2022 Financial Assurance Estimate Form (with pre-plat construction)

PROJECT INFORMATION		
The Cottages at Mesa Ridge	Date	4/1/2022
	PCD File No.

Financial Assurance Forms_v1 redline.pdf Markup Summary 5-12-2022

THE COTTAGES AT MESA RIDGE  
GOODWIN KNIGHT  
FOUNTAIN, COLORADO

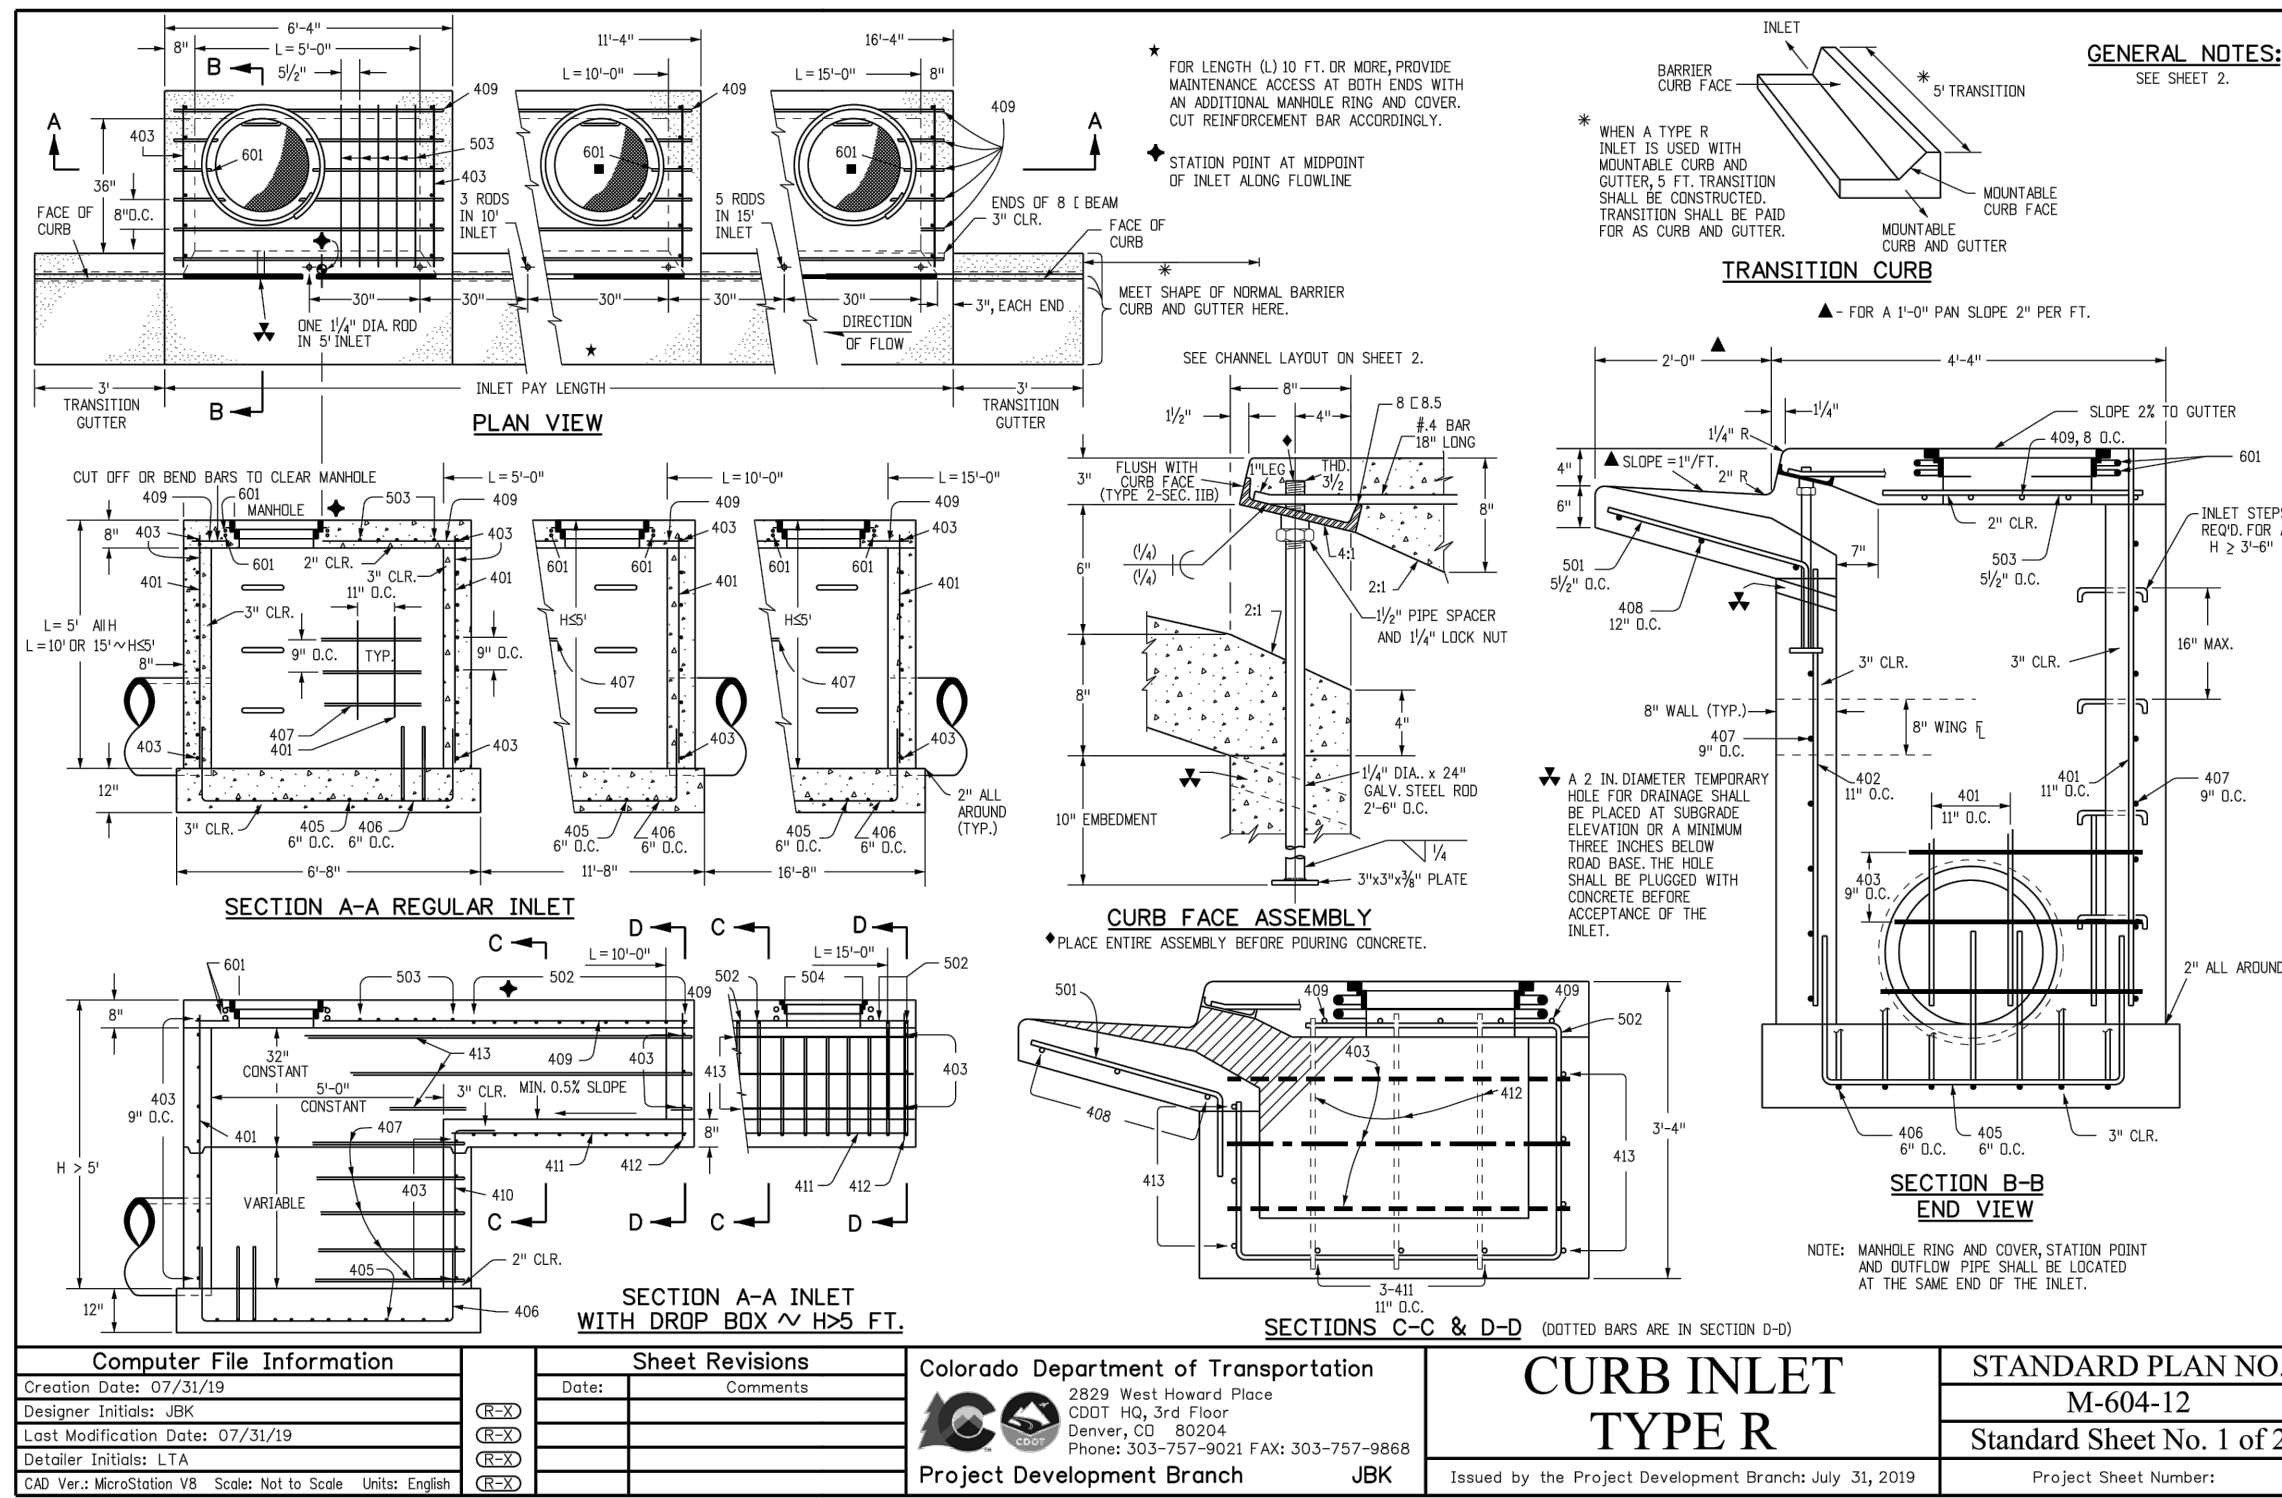
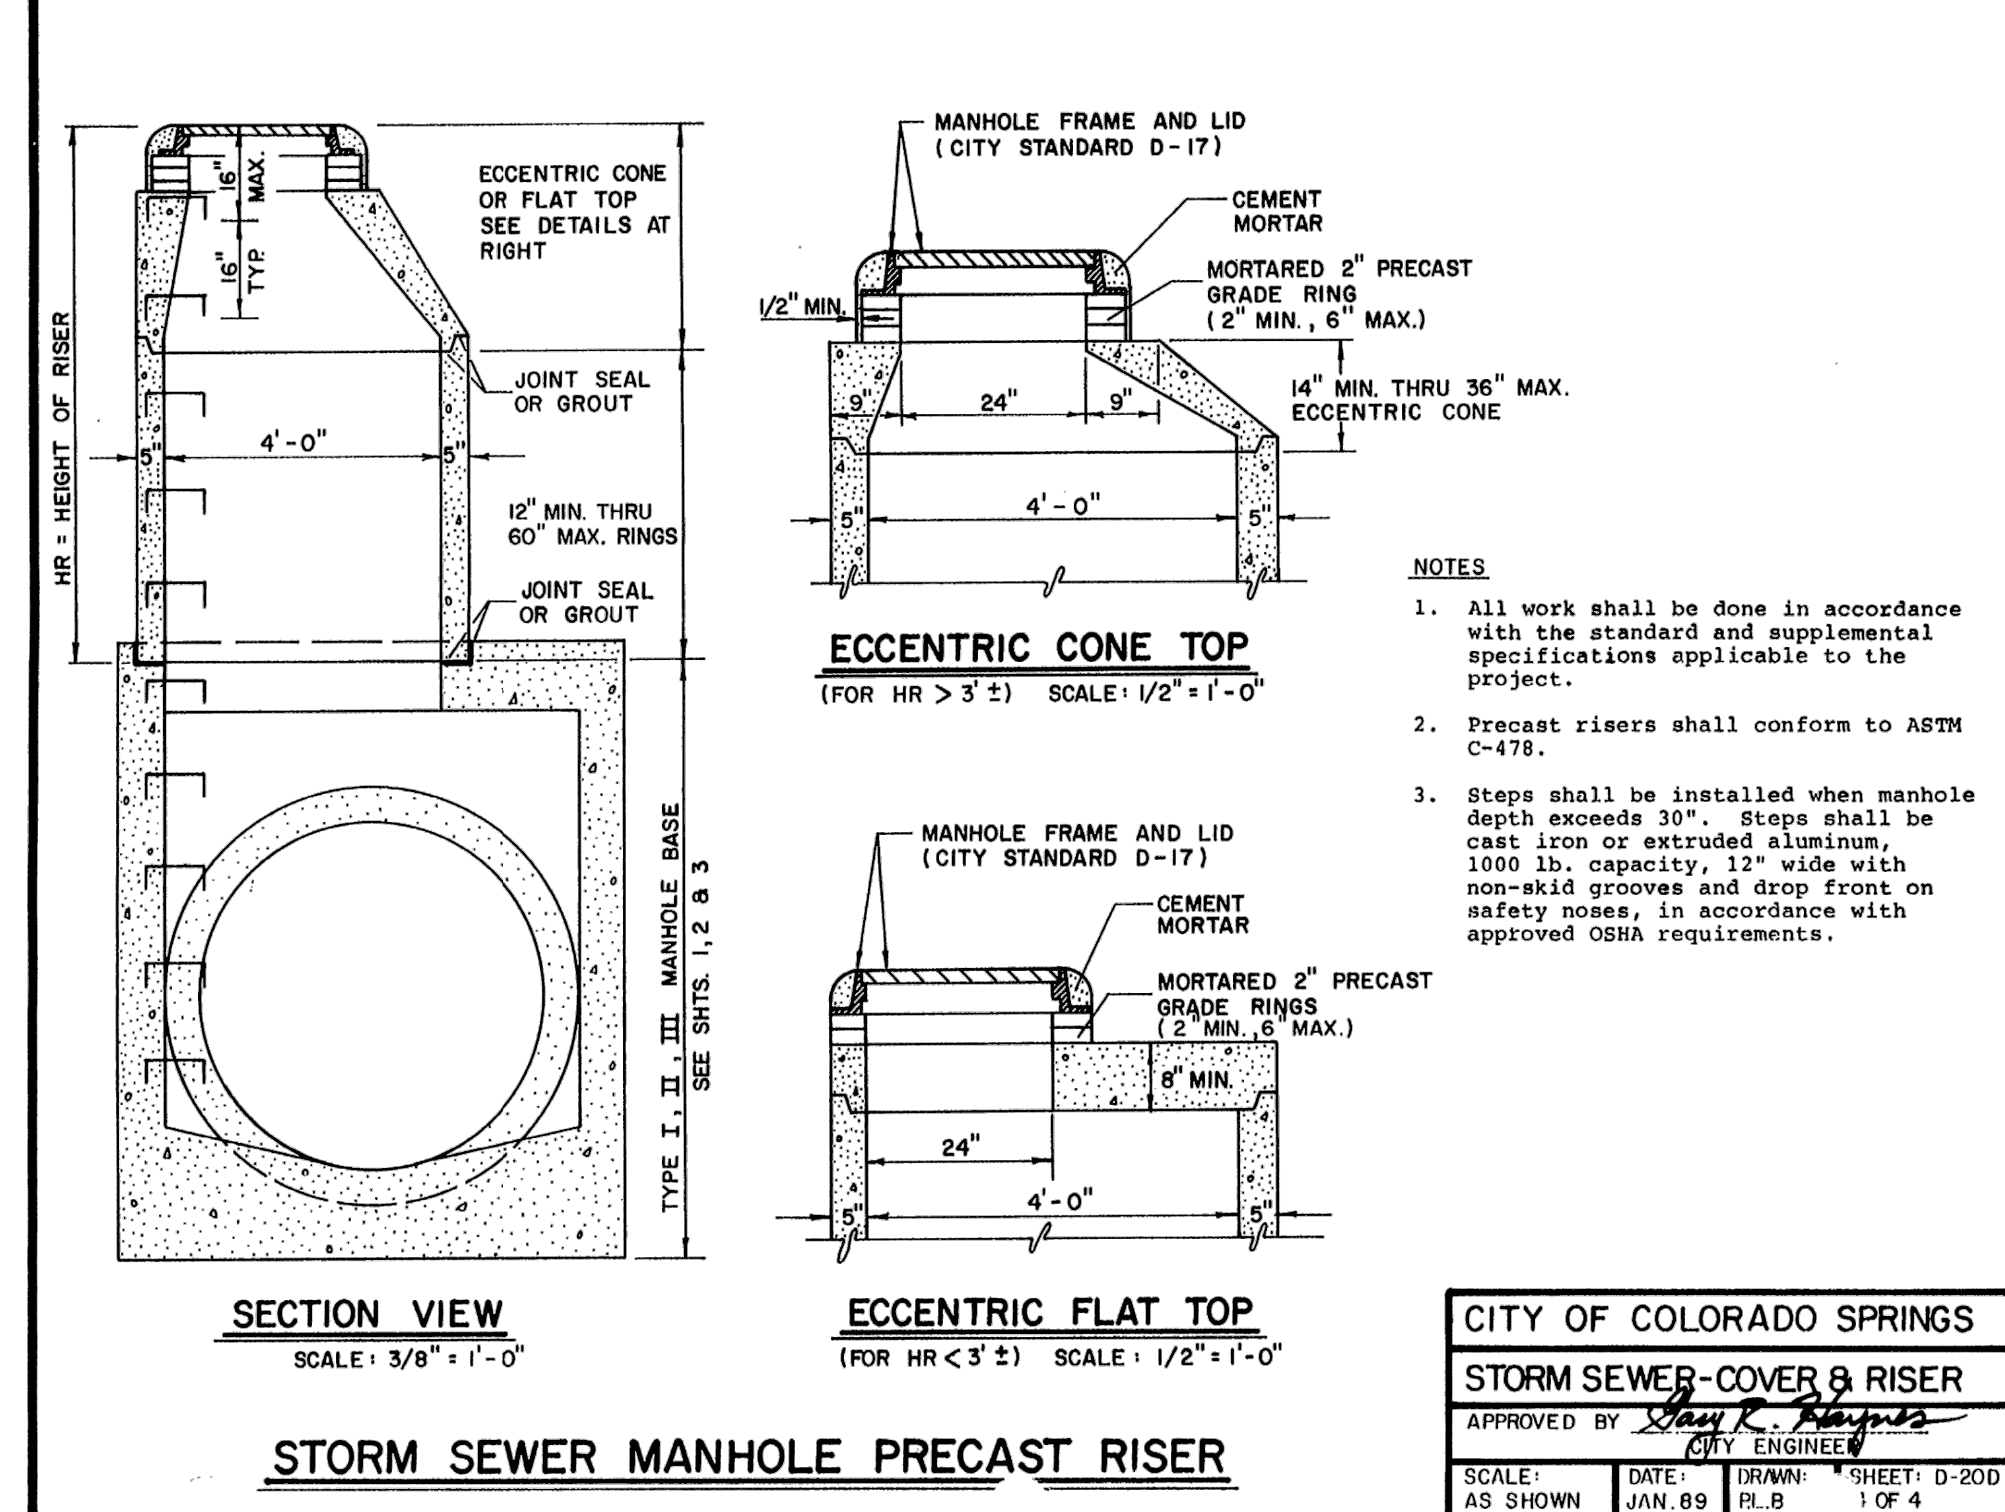
include outlet structure retrofit

HRG RESPONSE: ADDED TO SECTION 3
